Ribble Valley Borough Council
Church Walk,
Clitheroe,
BB7 2RA

Phone: 0300 123 6780
Email: lhscustomerservice@lancashire.gov.uk
Your ref:
Our ref: LHS/CS/3/2016/0146
Date: 17th May 2016

Proposal:	Outline application with all matters reserved for residential development of 23 dwellings , with access, parking and associated landscaping following demolition of Nos.23 25 Old Row
Location:	Old Row Whalley Road Barrow BB7 9AZ
Grid Ref:	373855 - 438540

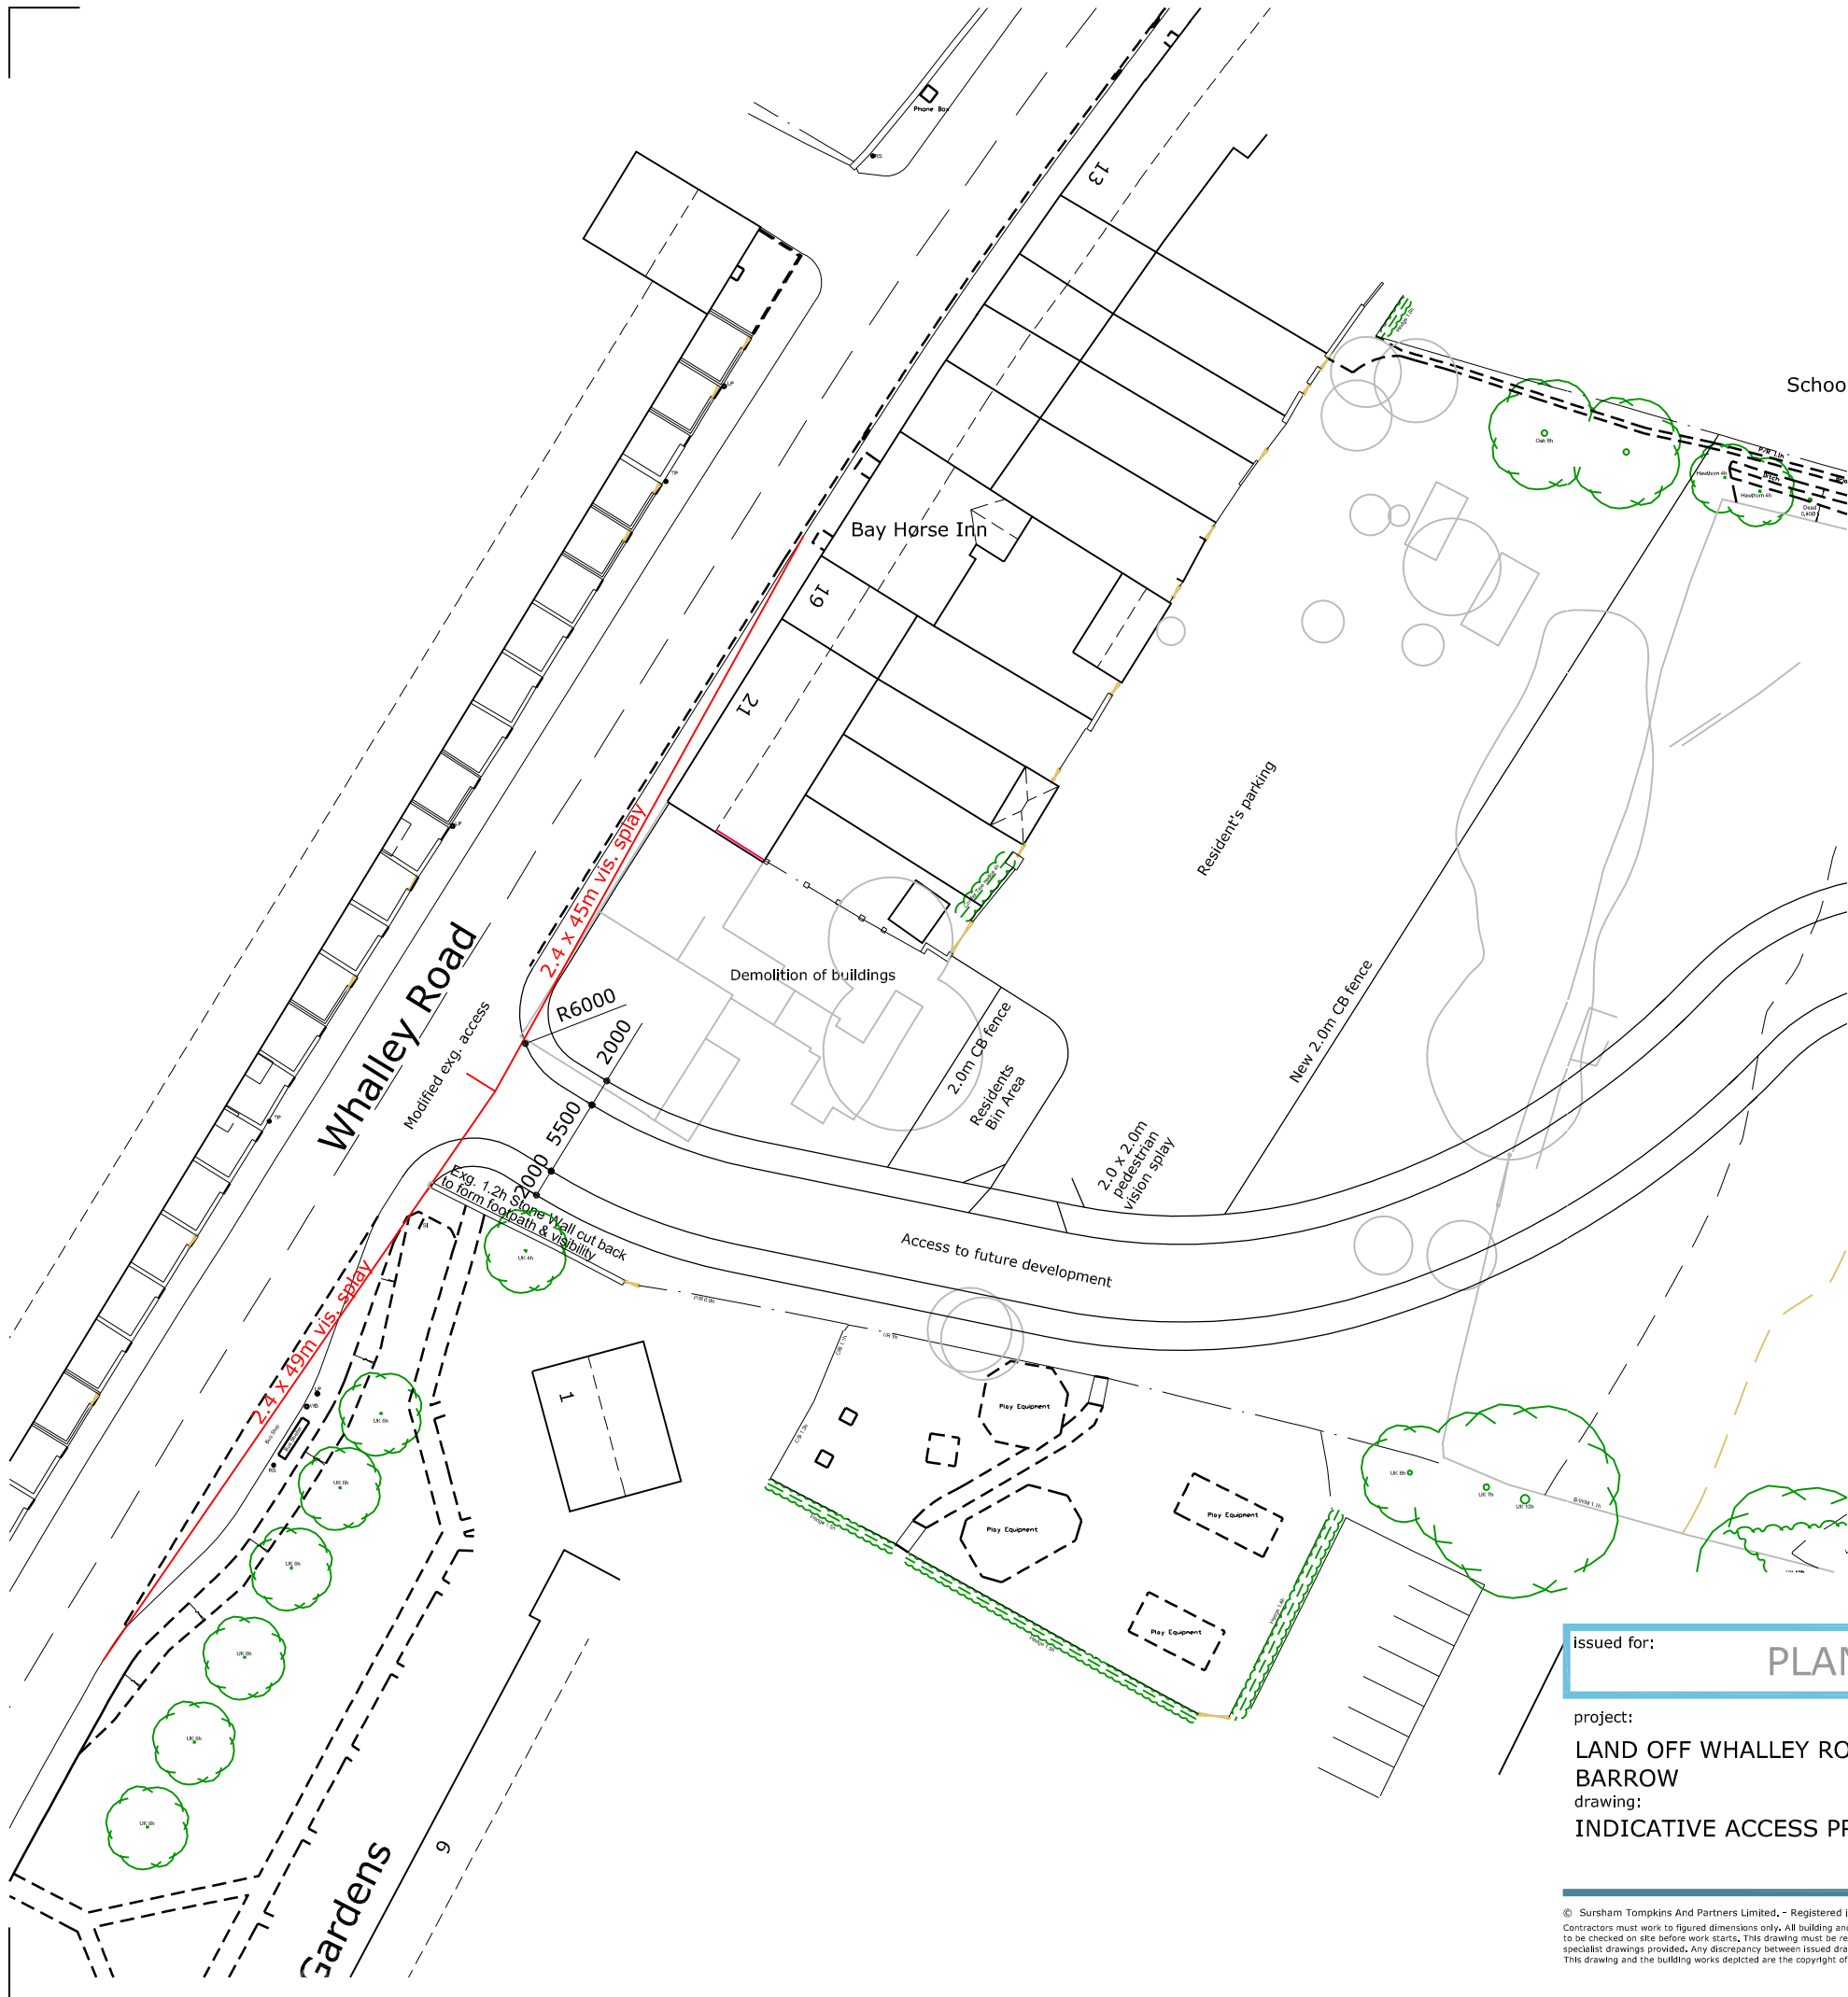
Using the basic formula for calculating Stopping Sight Distances from Manual for Streets and the traffic speed survey information the sight lines to be at least 2.4 x 51m to be provided in a southern direction and the sight lines at least 2.4 x 49m to be provided in a northern direction. The calculations for the recommended sight lines are provided at the end of this report. For the larger site 2.4x60m is proposed in both directions this will overcome any uncertainty on the use of historic data. I am however concerned that parked cars in the vicinity of the junction will obscure visibility to the north.

In addition the applicant should provide further information to ensure that a solution is provided on the above and to ensure that the land required is fully within the applicants control and/or over the adopted highway. It is not clear from the applicant's application if they have rights to remove part of the stone wall on the south of the site and ownership of the wall should be proved, also the sight lines would be partly over third party land..

The Highway Development Control Section is of the opinion that a carriageway narrowing (junction buildout) of Whalley Road at the site access would be considered acceptable due to the width of Whalley Road. This would overcome the land issues as well as improving the issue of parked cars reducing achievable visibility. The applicant should provide accurate details of the recommended road narrowing, before determining the application. TRO's may need to be considered in the vicinity and provided as part of the S278 scheme.

The Highway Development Control Section is of the opinion that the geometry of the modified site access is to prescribed design standards and the modified site access works within the existing adopted highway to be done under a section 278 agreement with Lancashire County Council. Any scheme to be agreed with the highway authority and its principles be agreed prior to the application being determined.

To overcome the issue of vehicles travelling at speeds that are greater than the limit of the road which will impact on safety at the new junction, the S278 works to include gateway features to the north yet to be agreed, could be similar/inline to those as recently discussed on the 3rd May with regard to the 3/2014/0846 appeal.

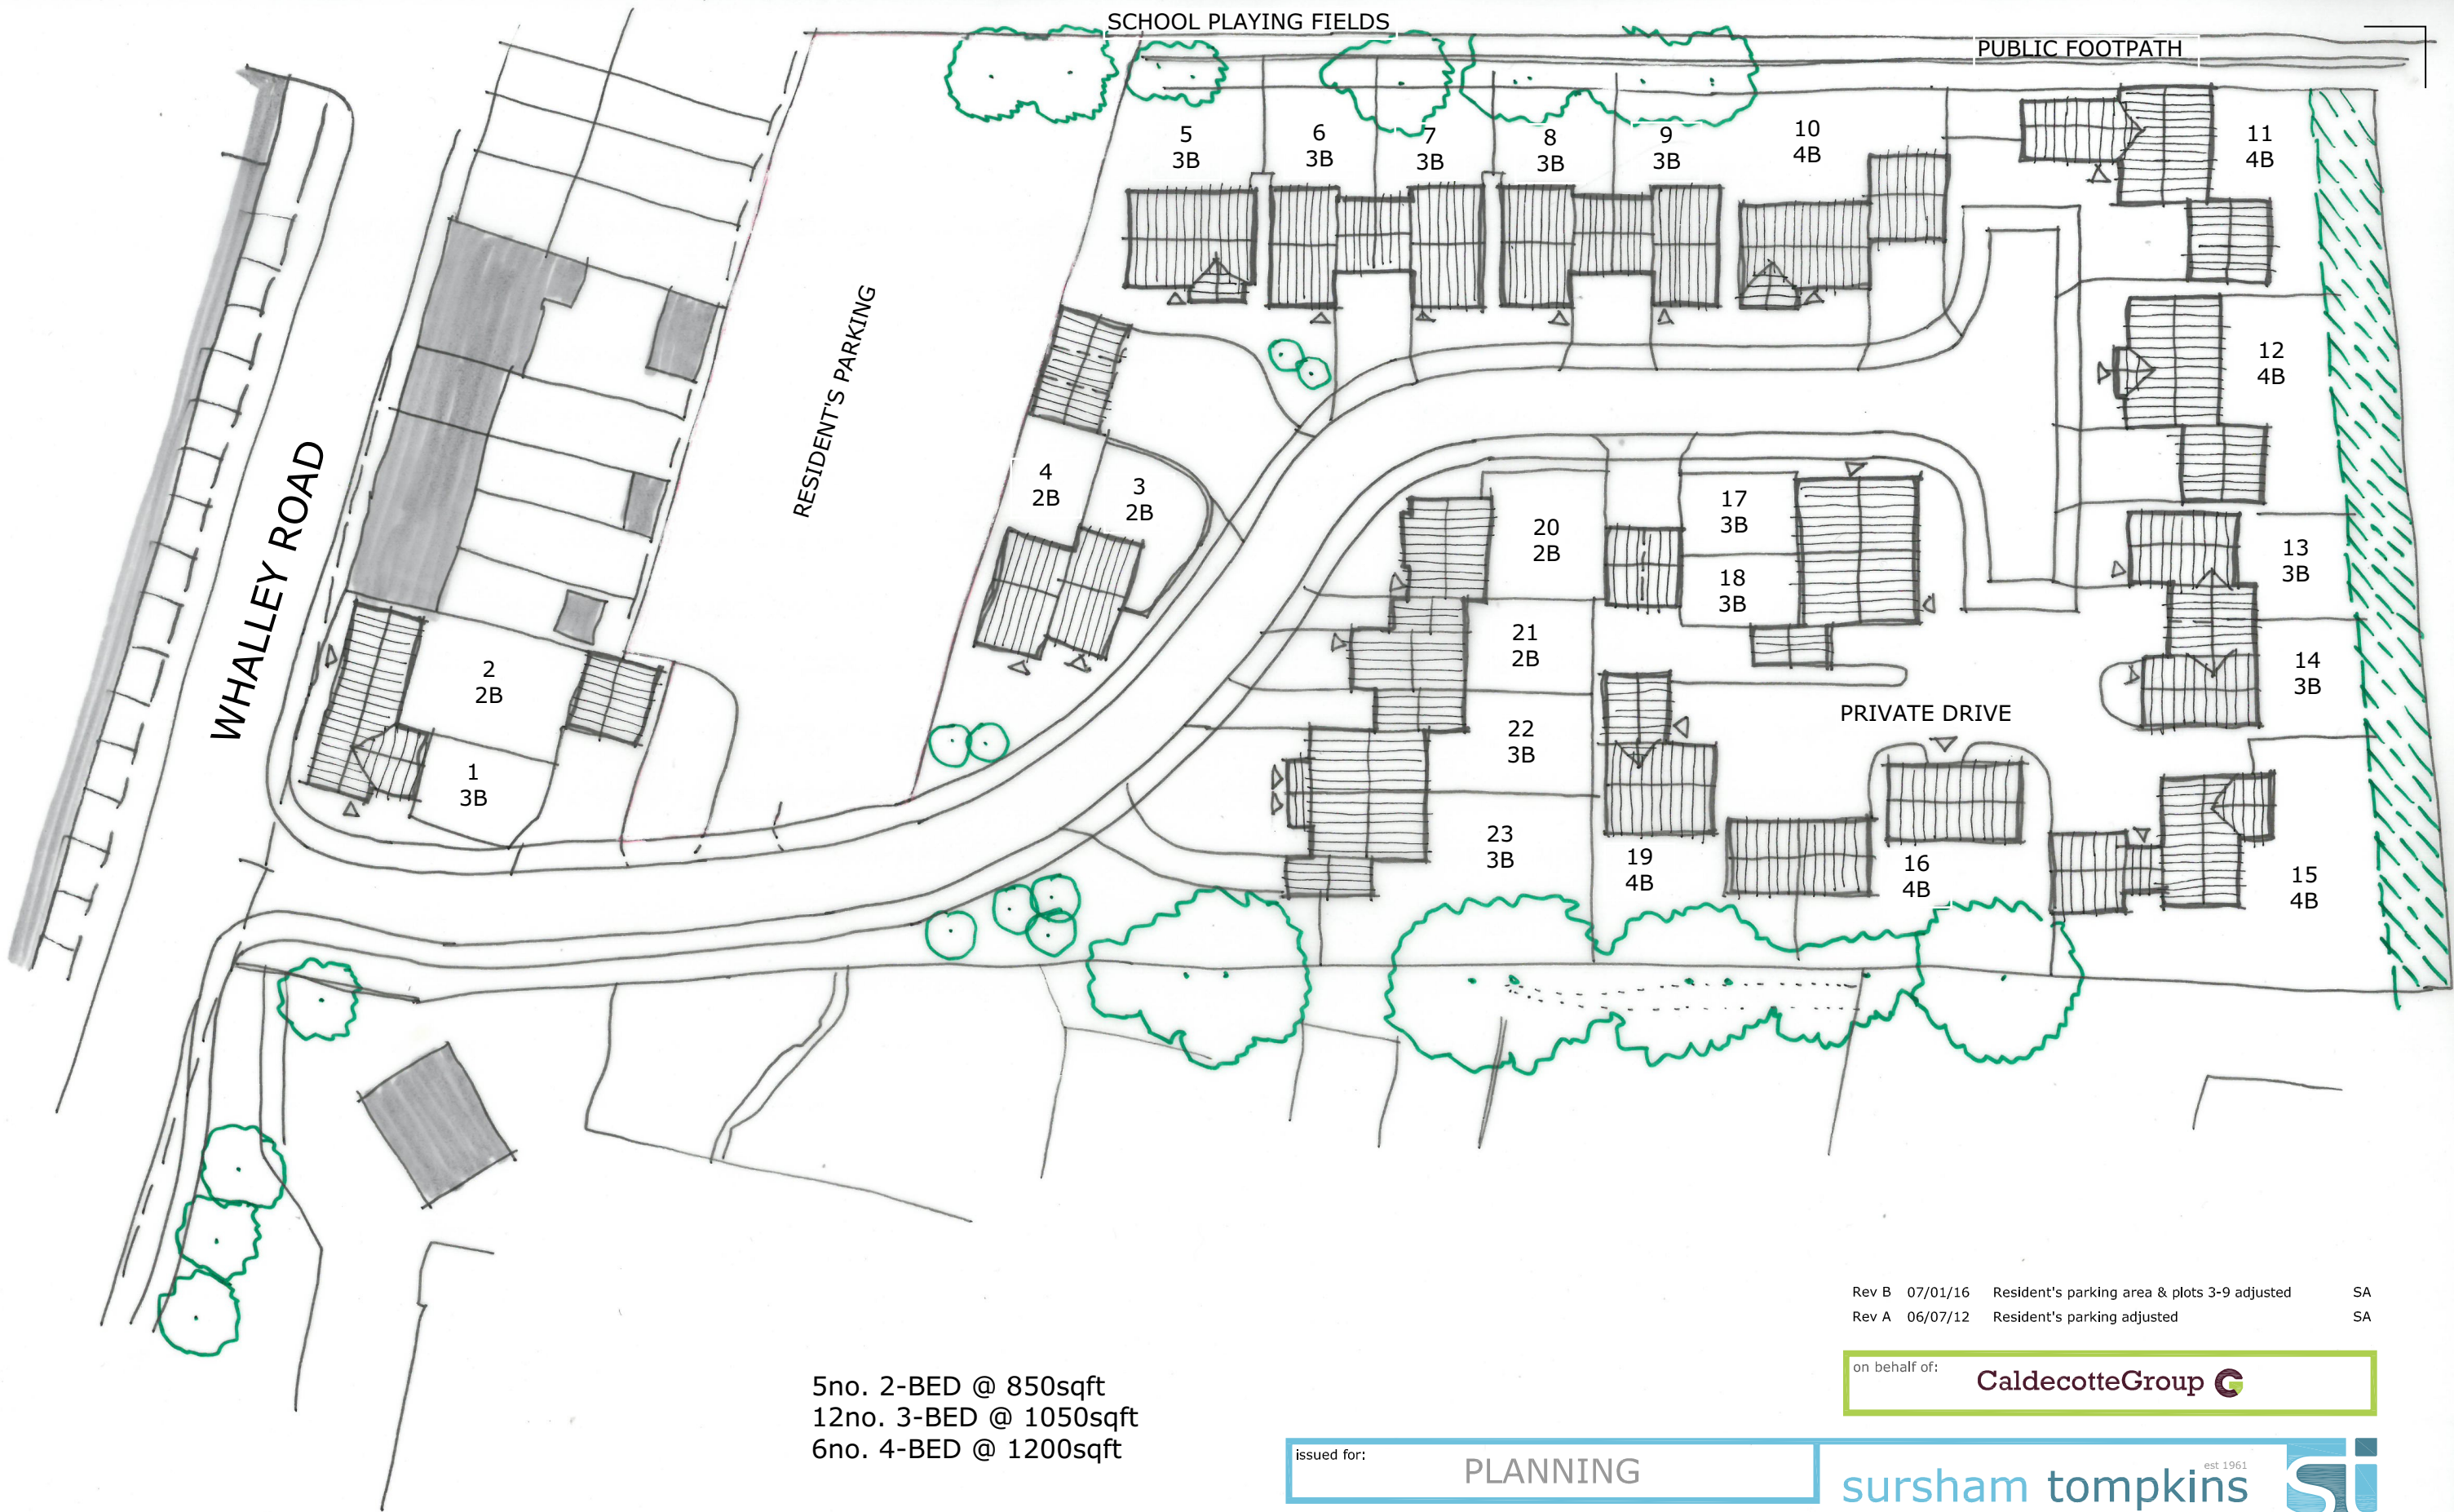
The Highway Development Control Section has made the following provisional comments regarding the internal layout of the site and the applicant is advised to consider these comments as part of any reserved matters planning application:-

1. The internal spine road is to be designed as a 20mph road with better use of horizontal deflection, rather than vertical deflection. Typically the speed reducing features to be at a maximum of 75m centres.

4. The minimum internal single garage size to be 6x3m and this includes integral garages.

5. The sight lines of 2.4 x 25m to be provided in both directions from the centre of the car parking access onto the new spine road. The site line requirement is based on table 7.1 from Manual for Streets and an estimated wet road 85th percentile speed of 20 mph.
6. The private drives to have a minimum width of 3.2m where they are used for vehicular access and pedestrian access to the property. From Approved Document M (Access to and use of buildings). Clause 6.15-b and 6.17-a require flights with unobstructed widths of at least 900mm.
7. To support sustainable transport and improve social inclusion, the site to have a 2m wide footpath connection with definitive footpath 3-47-FP to the north of the site.
8. To support sustainable transport and improve social inclusion the site to have 2m wide footpath connections to the two play area to the south of the site
